KITTITAS COUNTY FIRE MARSHAL'S OFFICE

Re: Meadow Springs (BL-10-00017)

After conducting a review of the above named project, I have the following comments:

DWN. BY	KMM	DATE	04/02/10	JOB NO.	12854
CHKD. BY	TSL	SCALE	1" = 200'	SHEET	2 OF 3

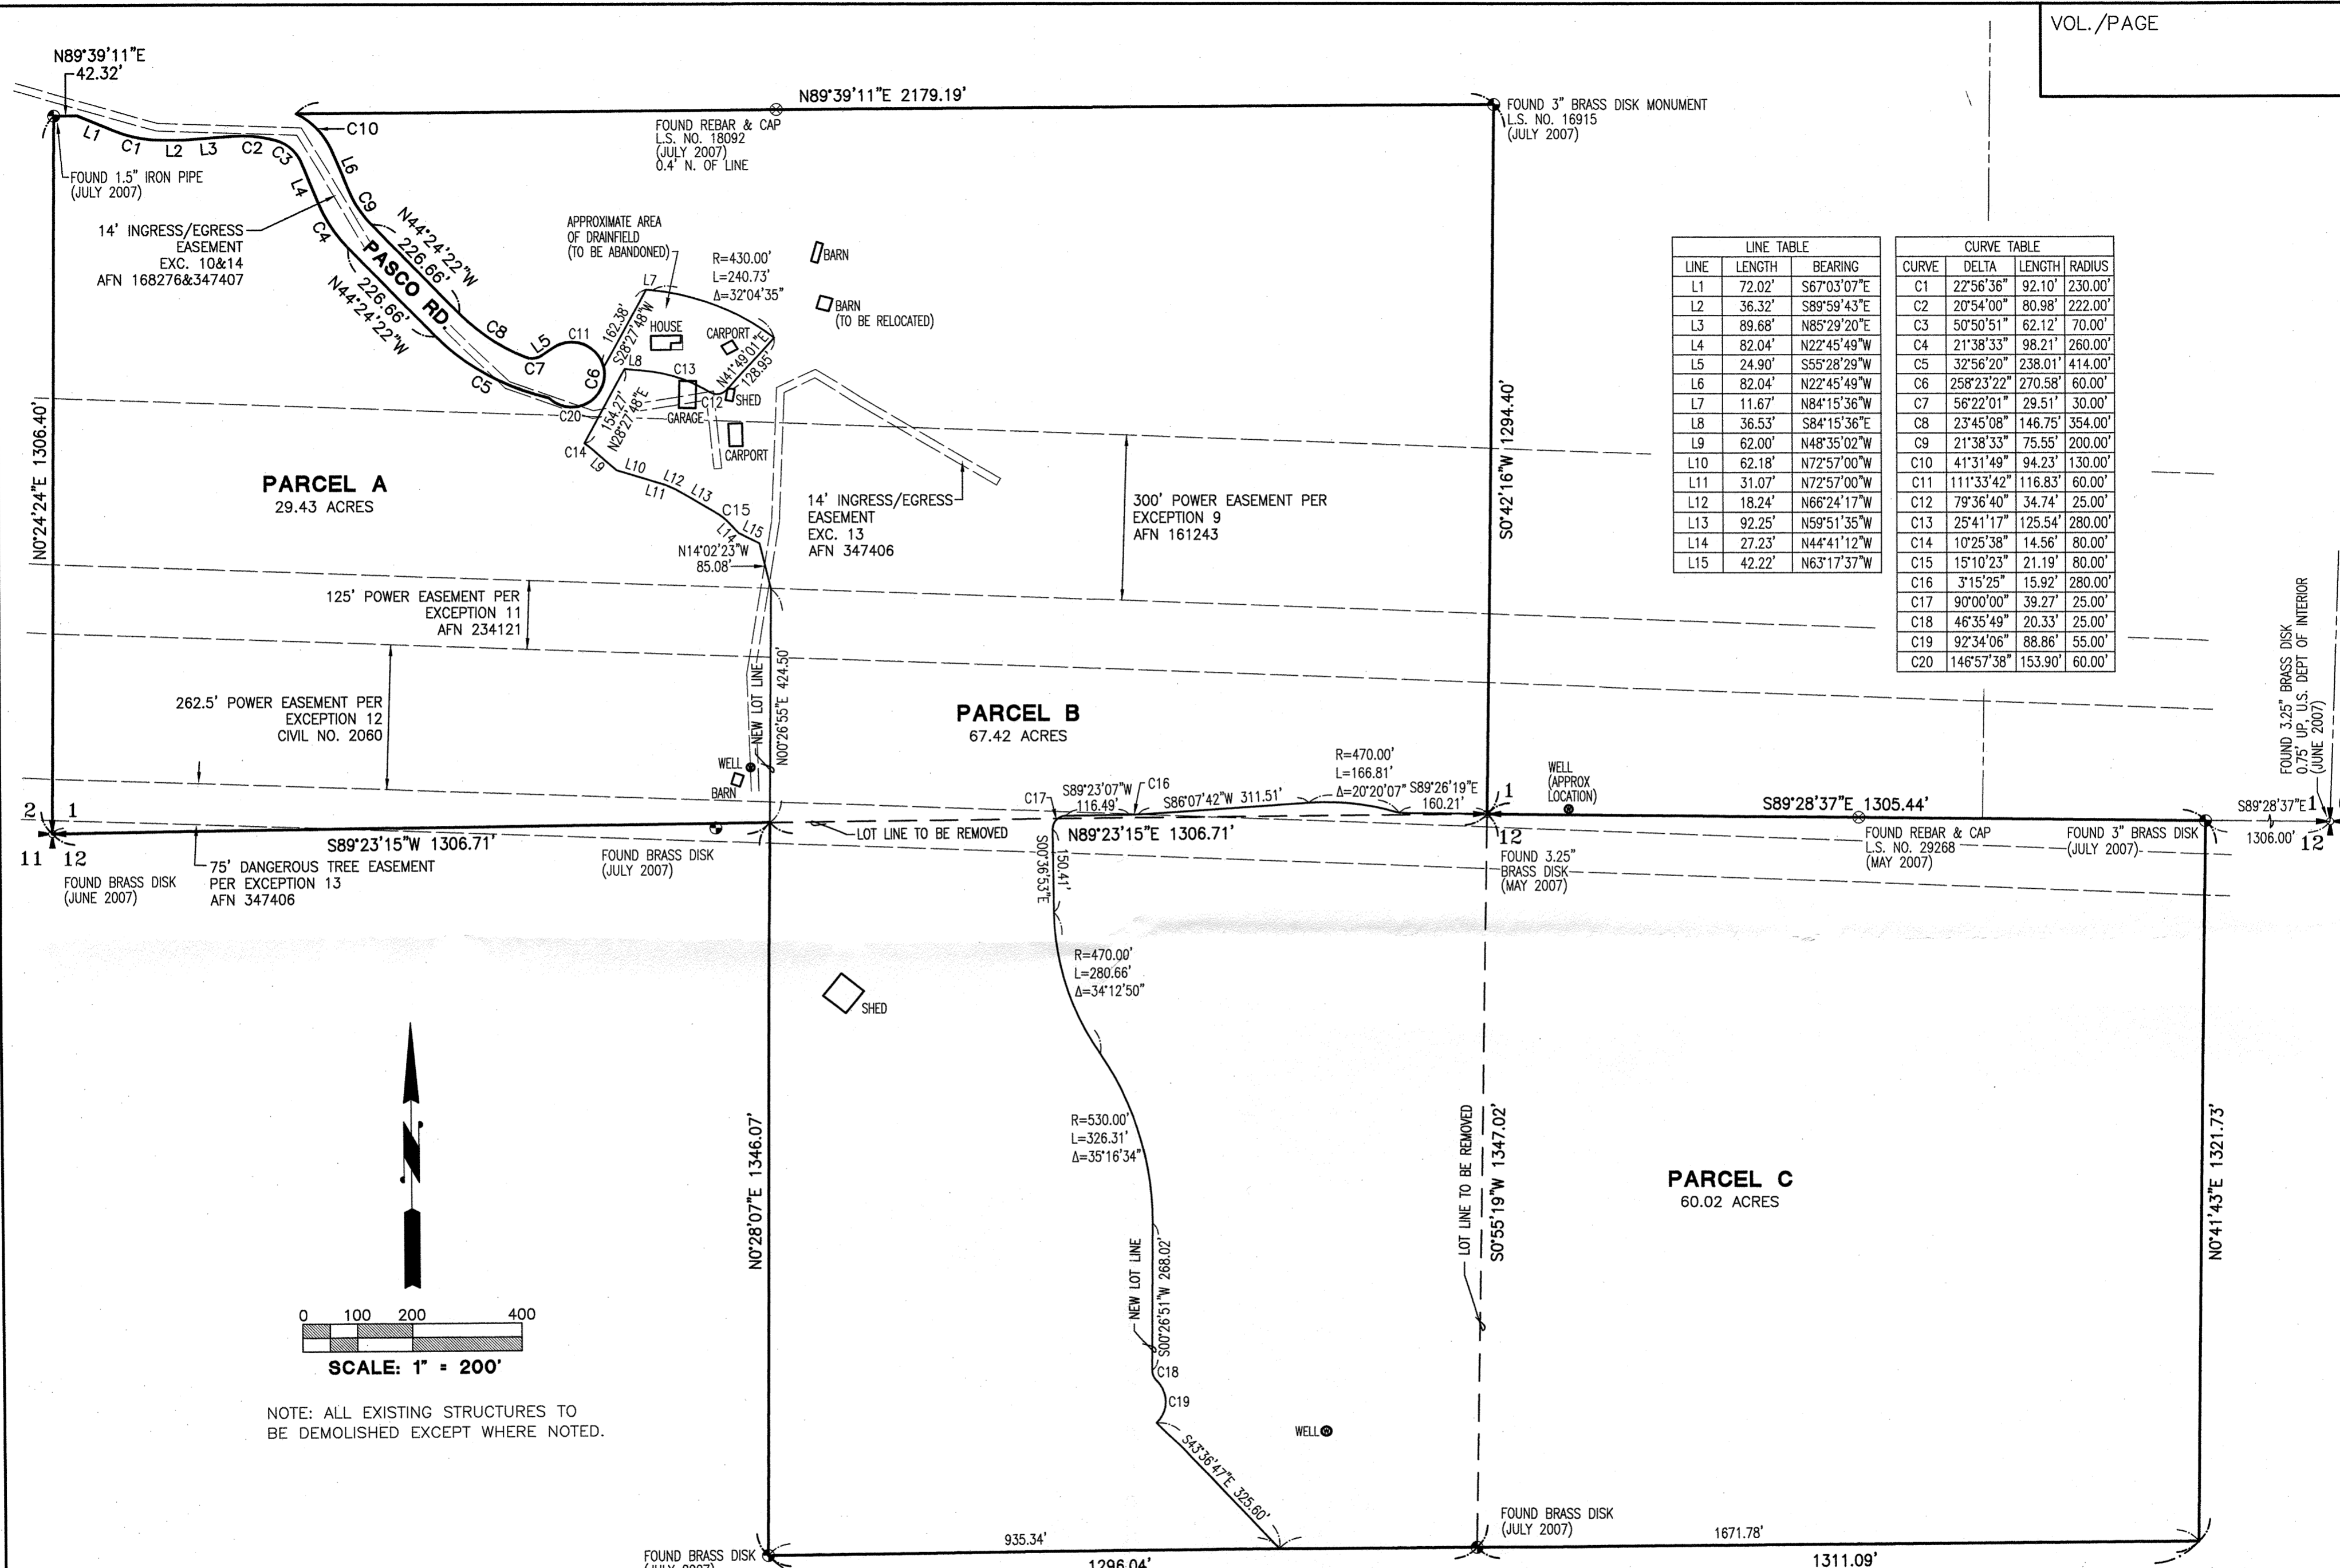
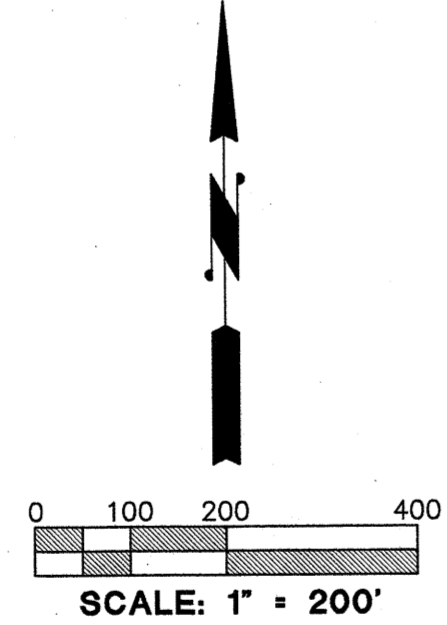
- Ensure that boundary line adjustments do not infringe upon existing structures, to include propane tanks, etc.
- Any additional roads or access must comply with the International Fire Code.
- All future development must comply with the International Fire Code.
